Charlotte Department of Transportation

Memorandum

Subject: Rezoning Petition 08-134: Located on the southeast corner of Selwyn Avenue and Queens Road West
(revised 8/15/08)

ILLUSTRATIVE SITE PLANS

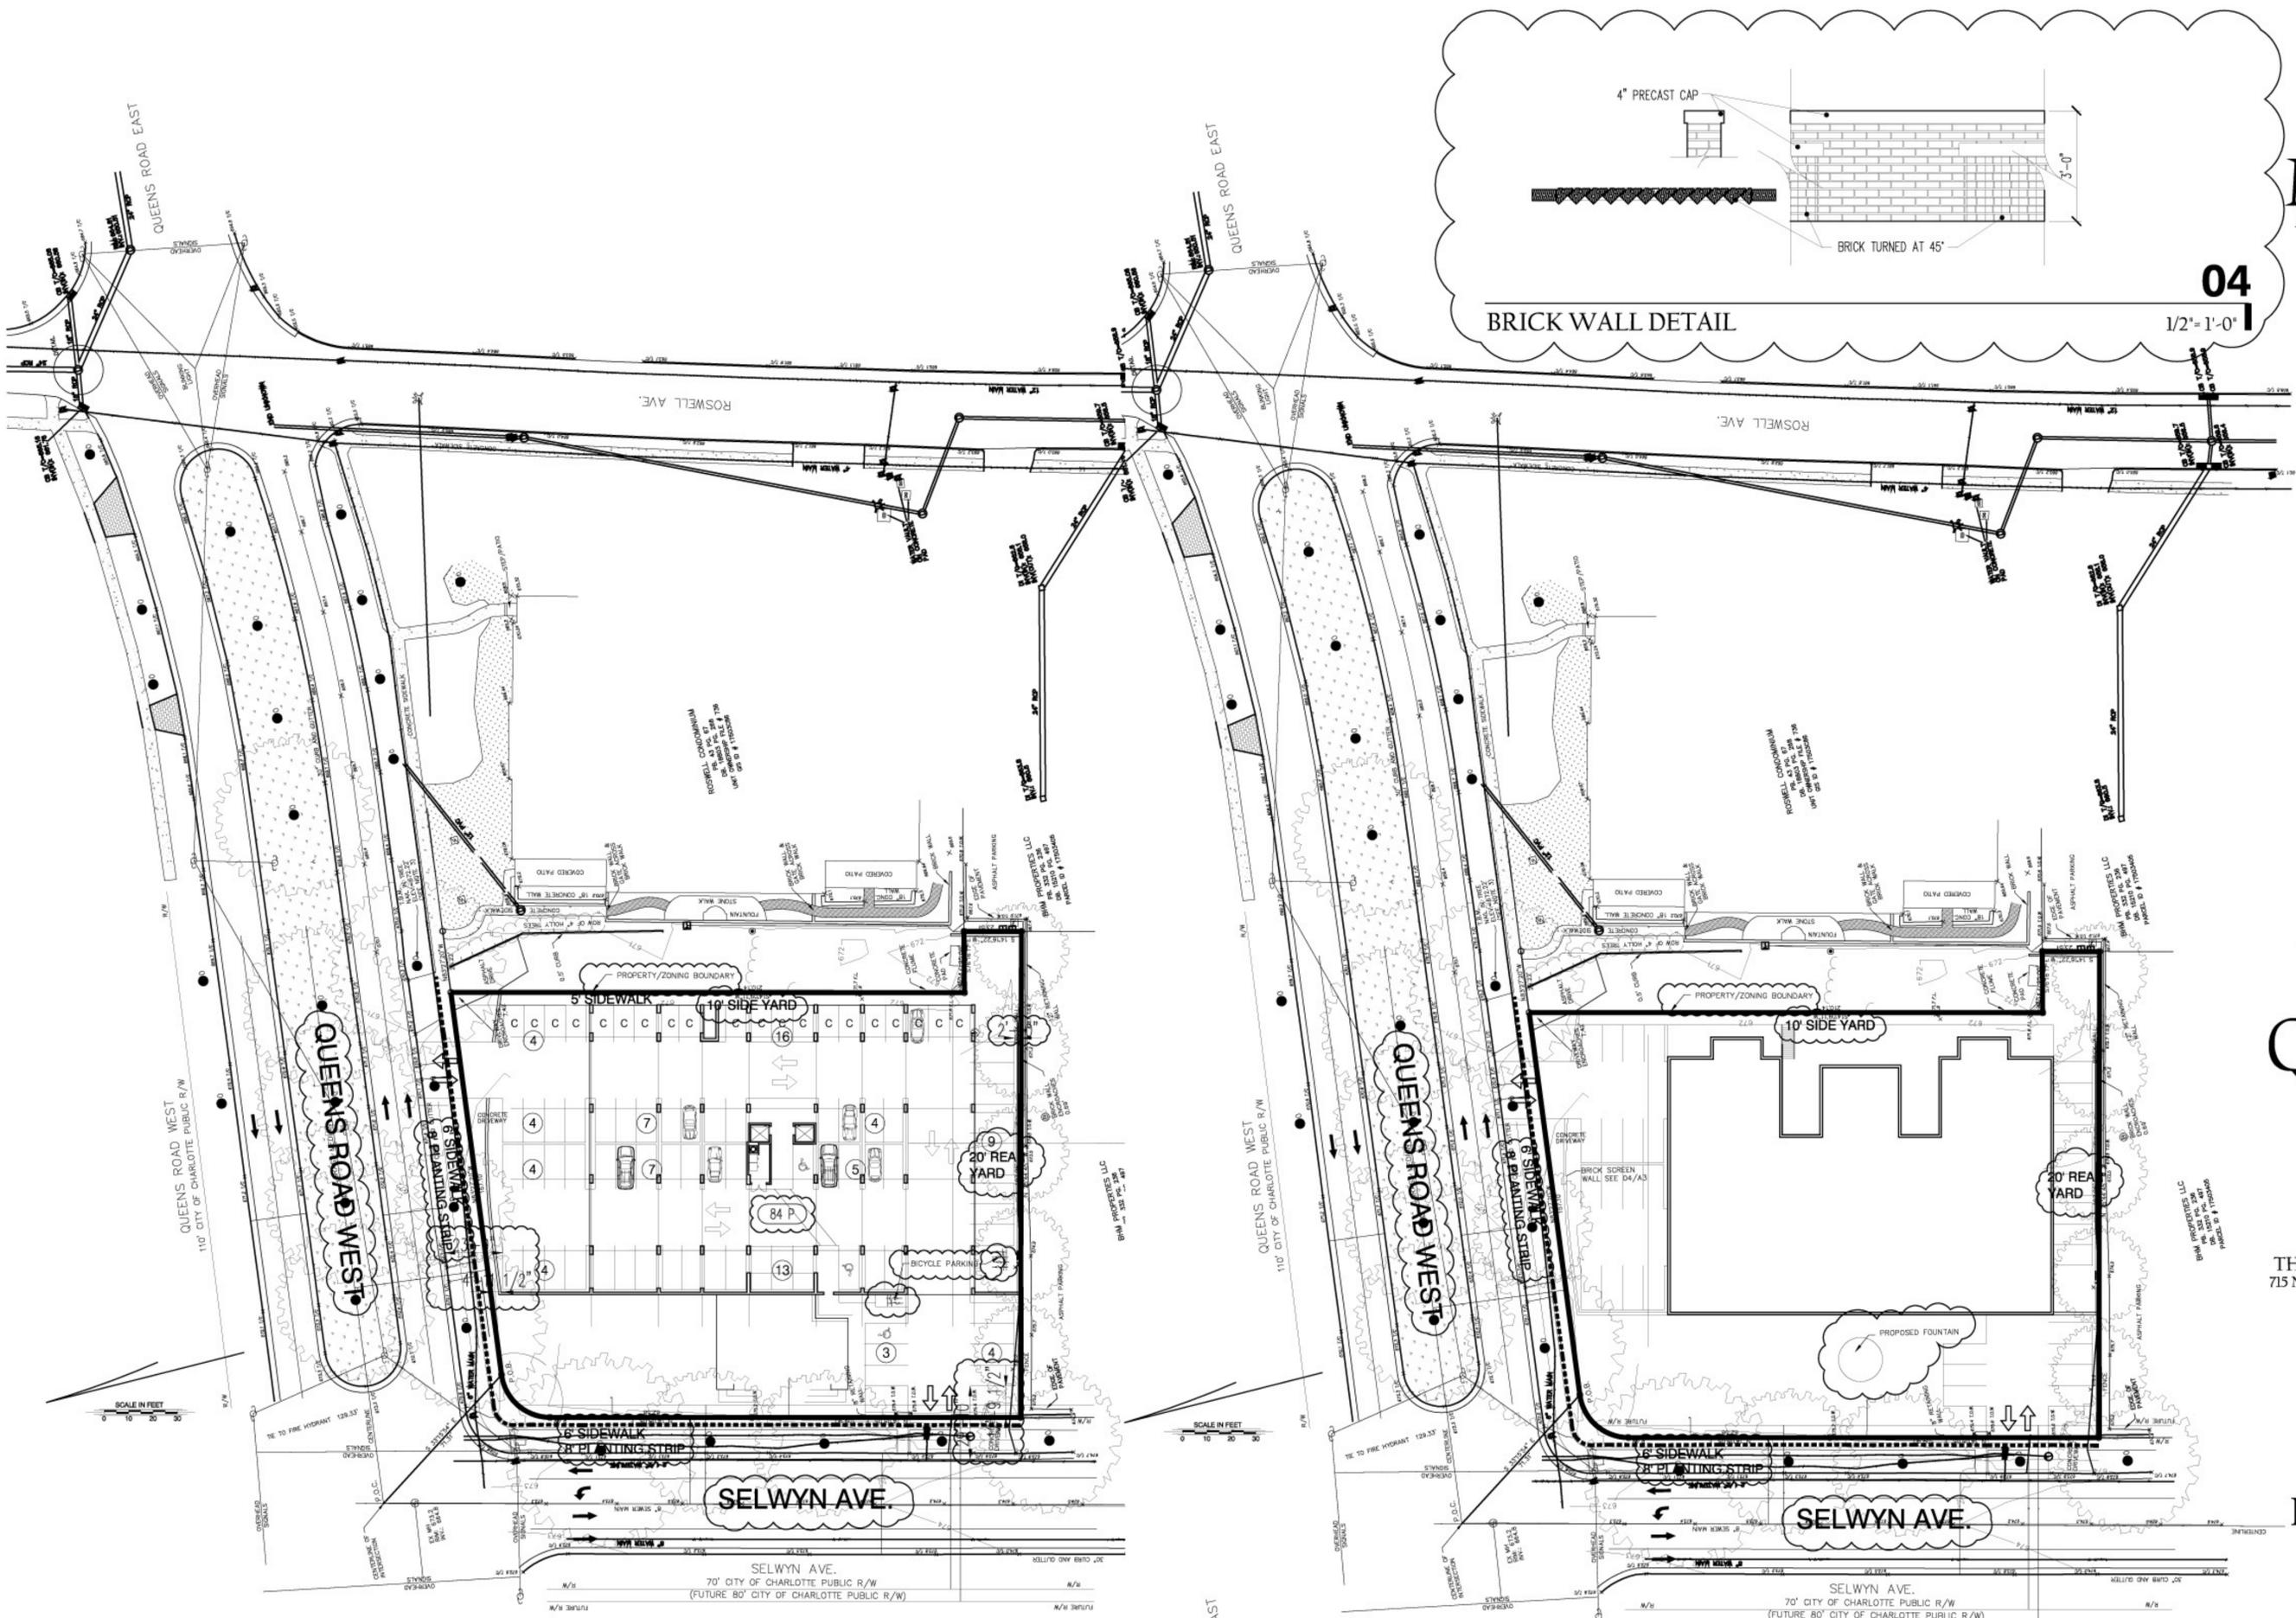
1. The proposed setback along Selwyn Avenue needs to be measured from the future curblineline which adds 2.5' to the face of the existing curb. The new sidewalk needs to be constructed at a location that is 11' (8' planting strip + 3' to back of proposed curblineline) from the back of the existing curb along Selwyn Avenue. (*Previous Comment-2*)
2. Selwyn Avenue is currently being evaluated for a road conversion via resurfacing that may provide two 4.5' bicycle lanes on paved gutters and a 3-lane cross-section of two 10' travel lanes and an 11' two-way left-turn lane (or 10' dedicated left-turn lane at intersections) and intermittent pedestrian refuge islands. To maximize the capacity of reduced lanes, the petitioner needs to eliminate the driveway on Selwyn Avenue, restricting access to only Queens Road West. (*Previous Comment-2*)

3. Selwyn Avenue is a thoroughfare inside Route 4 requiring a right-of-way of 80', measuring 40 feet from the centerline of the roadway. We request that an additional 5' of right-of-way be dedicated to meet this requirement and noted on the site plan. (*Previous Comment-2*)
